From: Claire Potts
Sent: 01 February 2019 14:01
To: Planning.Responses
Subject: FW: Land at Ryefields, Oak Tree lane, Woodgate (e-mail 1 of 2) App Ref AL/118/18/OUT

Further to our previous conversations and the subsequent consultation process, please find enclosed our additional documentation in support of our application. Due to the size of the attachments, I have spread over two e-mails:

Rev A 30.01.2019
Access amended and grasscrete area added
Verge cut back; kerbline adjusted; bin
collection areas re-located.

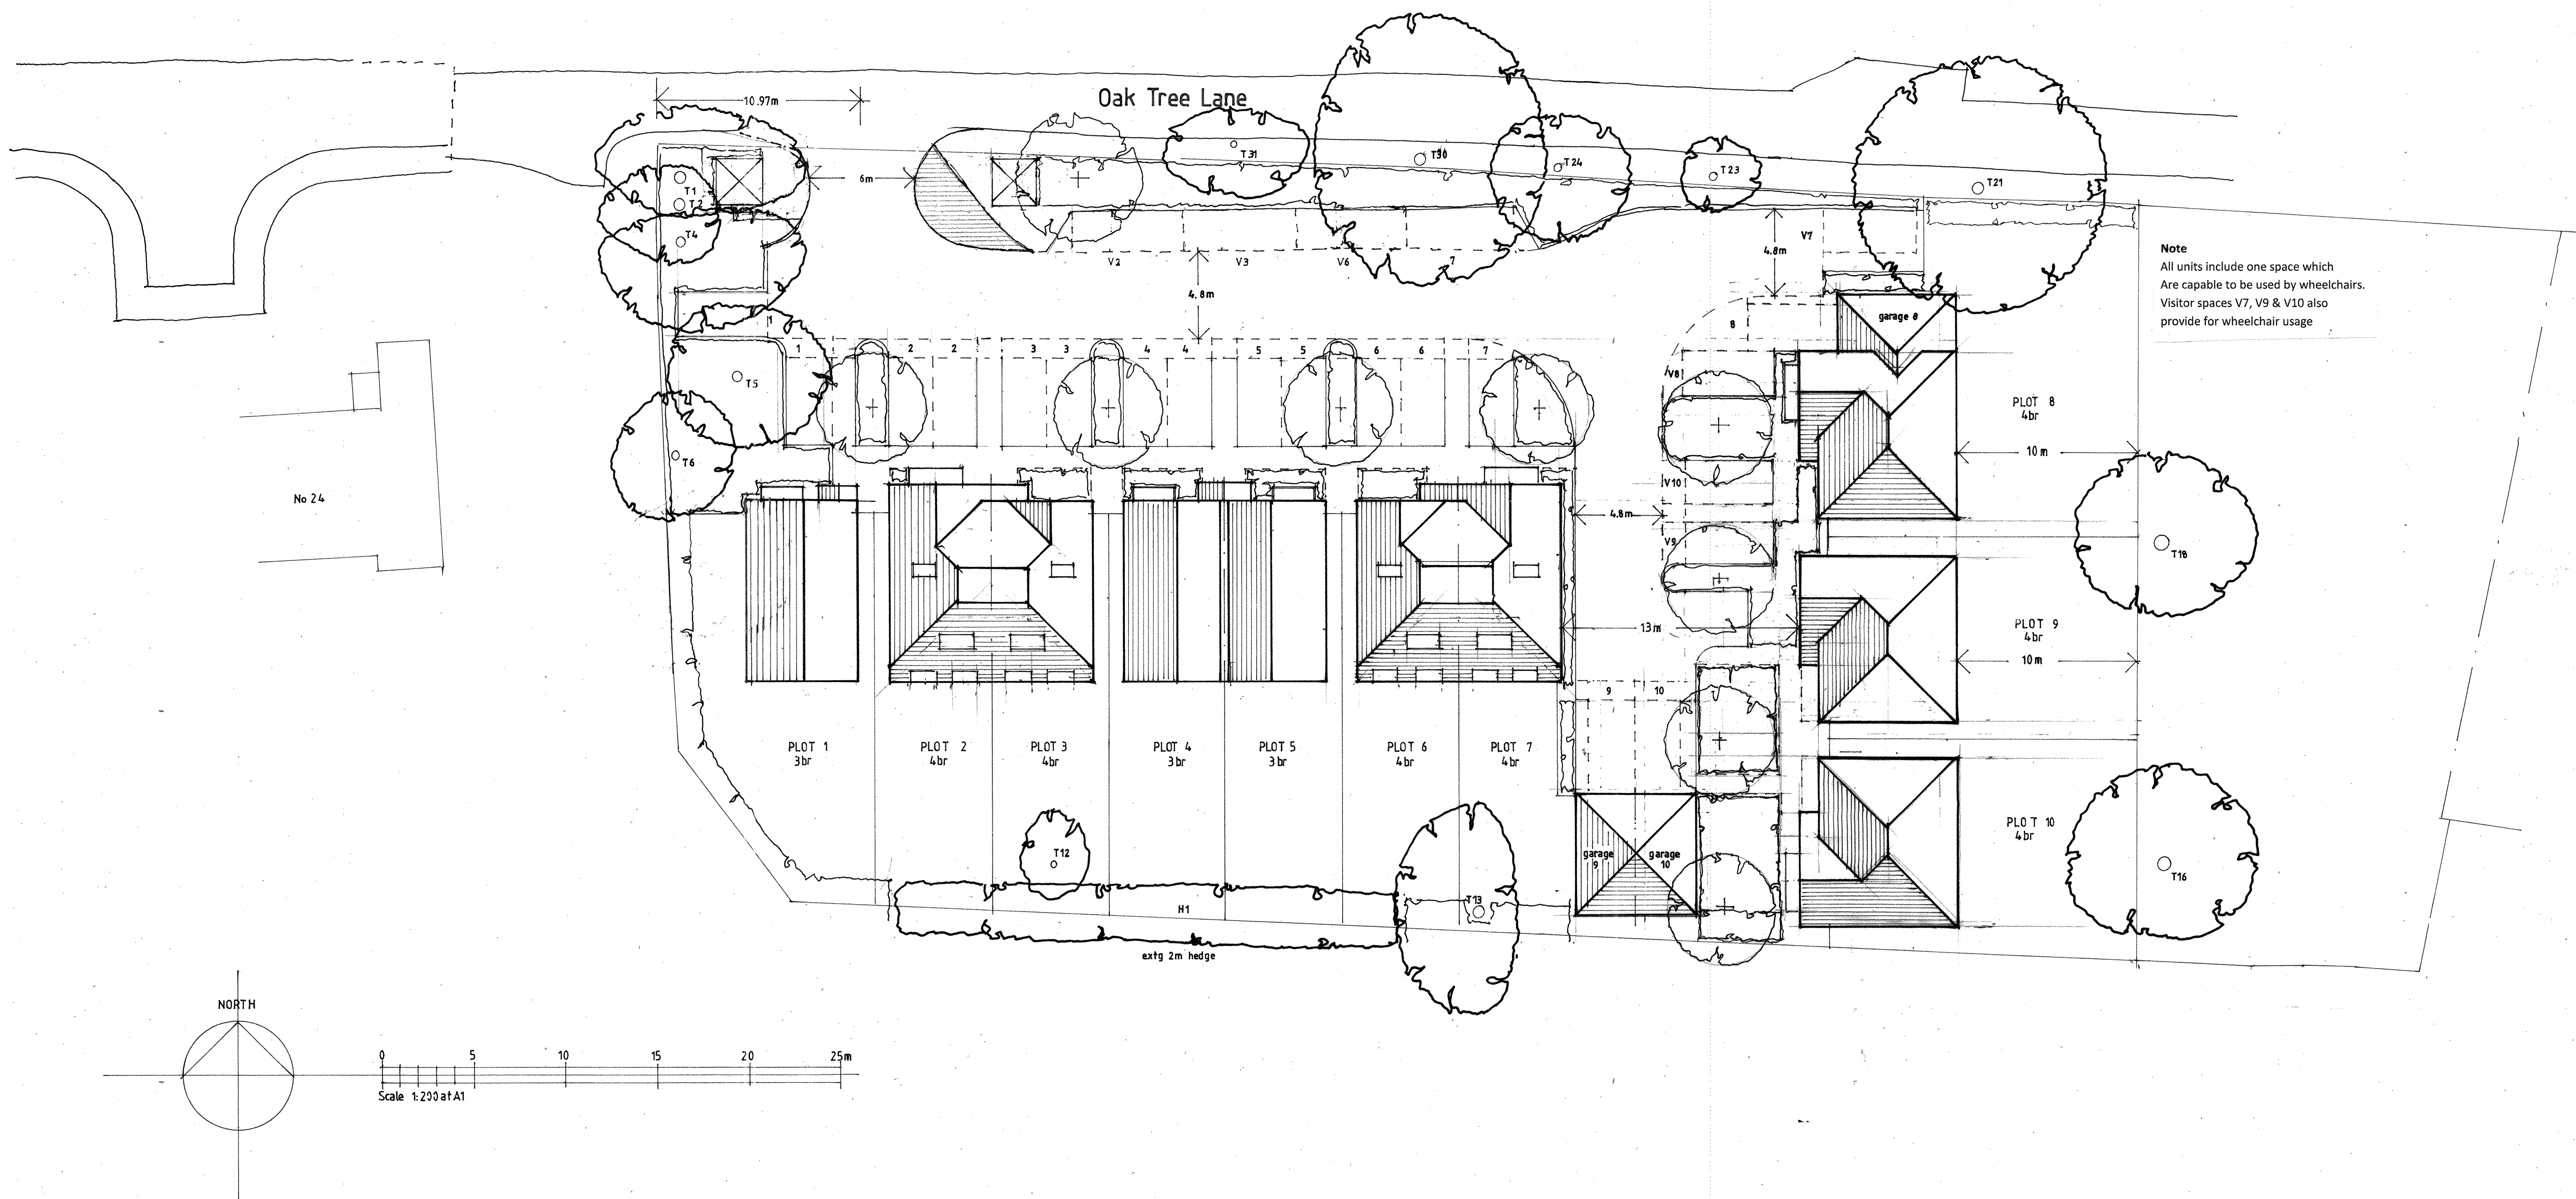
The site plan has been amended by the widening of the access to allow both refuse vehicles and fire appliances to enter and exit the site efficiently. This has been created by way of a grass Crete area to the north west point of the access (please refer to ground floor plan). Visitor parking bays have been moved along to the east, with bin collection points moved further along on both sides. This also further assists the larger vehicles in terms of manoeuvring sufficiently and further improve sight lines.
